From: Anita Gardner
Sent: 13 September 2017 16:08
To: Planning.Responses
Subject: FW: FG/108/17/DOC - Condition 4 Internal Noise levels - Ferring

Subject: FG/108/17/DOC - Condition 4 Internal Noise levels - 1 Bennett Gardens, Ferring

SA - 5031

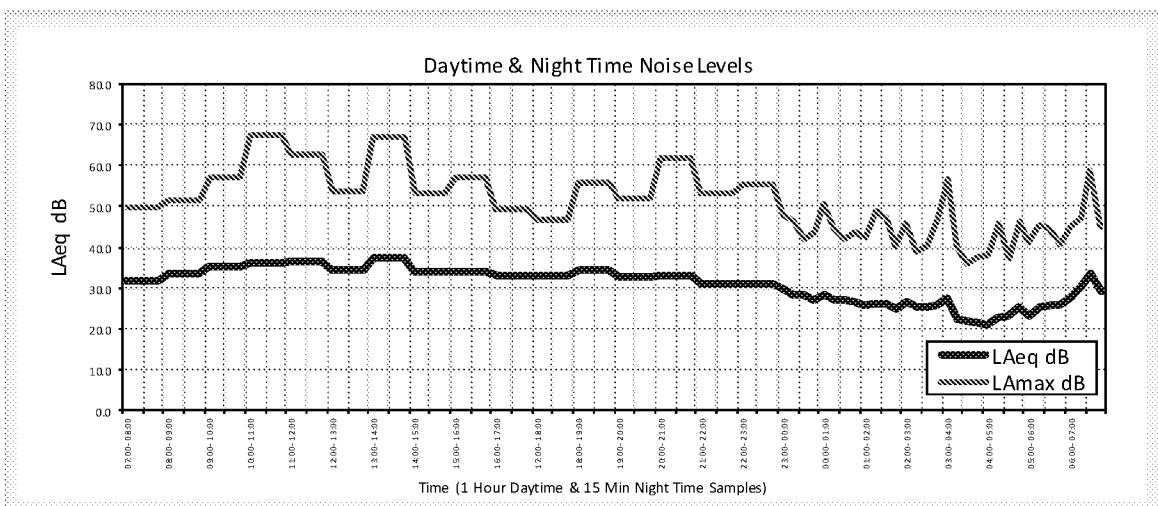
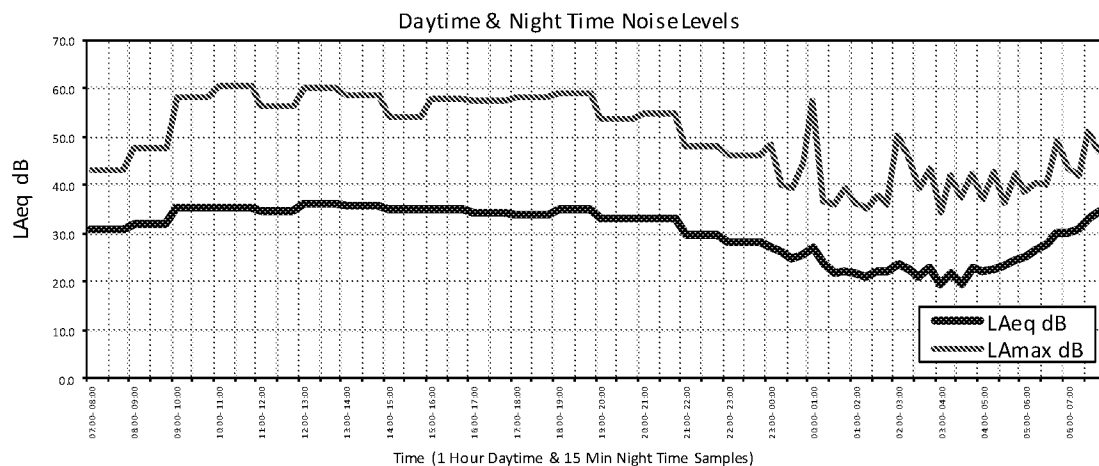
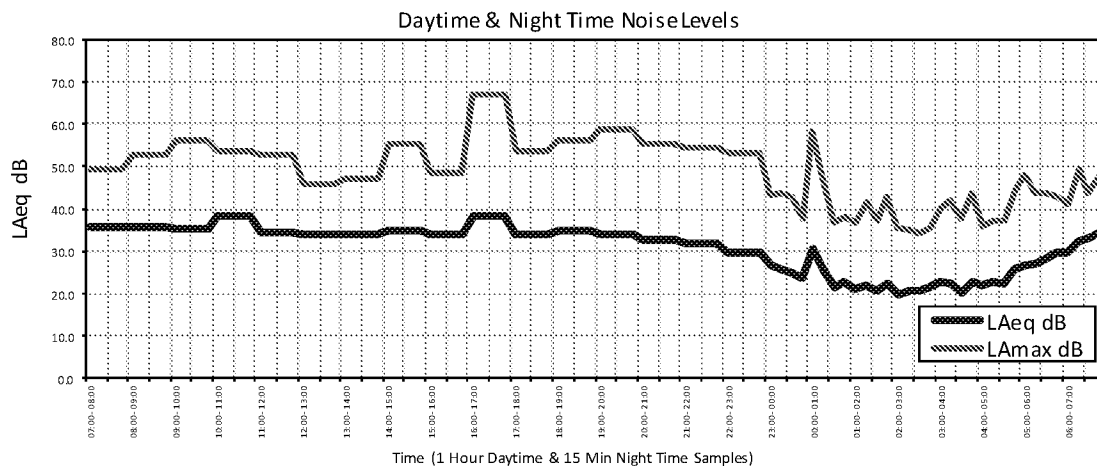
I write to confirm detail of our conversation, 24th August 2017, when I advised that the average sound level of those 2 rooms tested accords with the requirements of BS8233:2014, but not in respect of impact noise. The above reports clearly demonstrate the unacceptably high frequency of noise events affecting these rooms, defined as greater than 12 events of, or above 45dBLAFMax during the night time period 23:00 to 07:00hrs. This was on Saturday night 1st/2nd July 2017 (15 events) at Plot 4 and on each night, Saturday 24th/25th June 2017 (22 events); Sunday 25th/26th June 2017 (20 events) and Monday 26th/27th June 2017 (924 events) tested at Plot 40 (NB variance in house numbering).

'Refuse application for discharge of Condition 4 in respect of post validation testing to determine compliance with the requirements of BS8233:2014. Those Acoustic Reports provided by Sound Advice Acoustics Ltd, Ref SA -5031 in respect of Plot 1-4 (1st to 4th July 2017) and SA – 4993 in respect of Plot 37 – 40 (24th to 27th June 2017) clearly demonstrate an unacceptably high incidence of peak noise, defined as 45dBLAFMax, within first floor bedrooms during night time hours. This is despite investigations having taken place predominantly over the week end, when traffic flow might be expected to be less. Please provide detail of those further mitigation measures which will be provided to achieve the required standard. Any further post completion validation testing to be carried out on at least 2 days within that period Monday to Friday.

With regards to the comments recently received from the local councils Environmental Health Department we would like to confirm that our past testing noise report and assessed noise levels have been conducted strictly in accordance with BS 8233 : 2014 as requested within the aforementioned planning condition. For verification, BS 8233 : 2014 does not set nor require any L_{Amax} dB criteria for internal noise levels within bedroom. Furthermore, the planning condition does not request past testing for L_{Amax} dB noise levels.

Therefore the noise report issued has demonstrated compliance with BS 8233 : 2014 and the planning condition should be discharged accordingly.

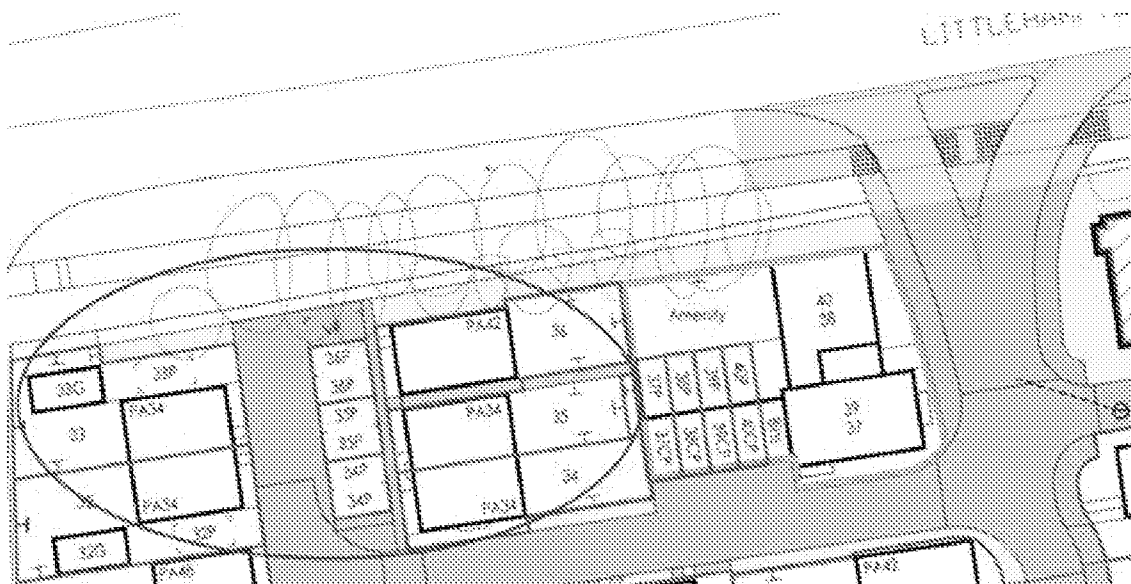
My question was regarding the remaining units which as you will see in the below image have only plot 36 adjacent to the a259 with 35 and 34 protected by 36.

We intend on carrying out the testing in 2 weeks time so to avoid any disruption I wanted to check if this was an error and instead the condition should state 33 and 36 or if you would like me to carry out testing to the 3 units listed in the condition?

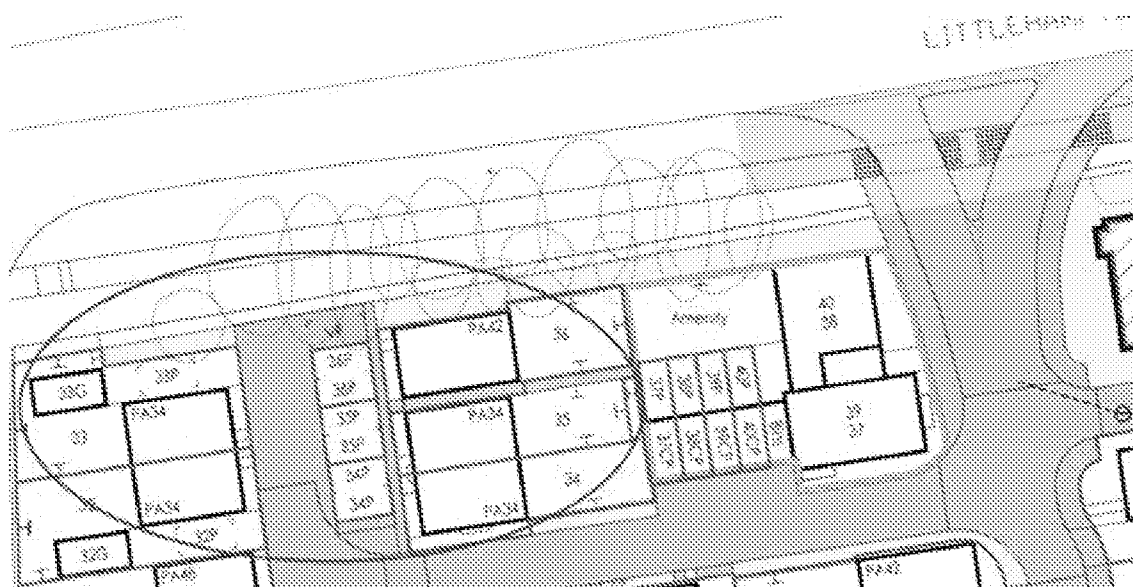
Going forward we still are due to test more plots alongside the A259. The condition does ask for testing of 3 plots (34-36) however only one of those plots front on to the A259 and we intend on testing the two left on site that do (33 and 36). Please see the exert of the site below for reference.

Can you please confirm that you would like Taylor Wimpey to test plots 33 and 36 instead of what is stated in the condition as 34-36 that contains two units that are shielded by plot 36 or if you would like us to test all 3 units as stated?
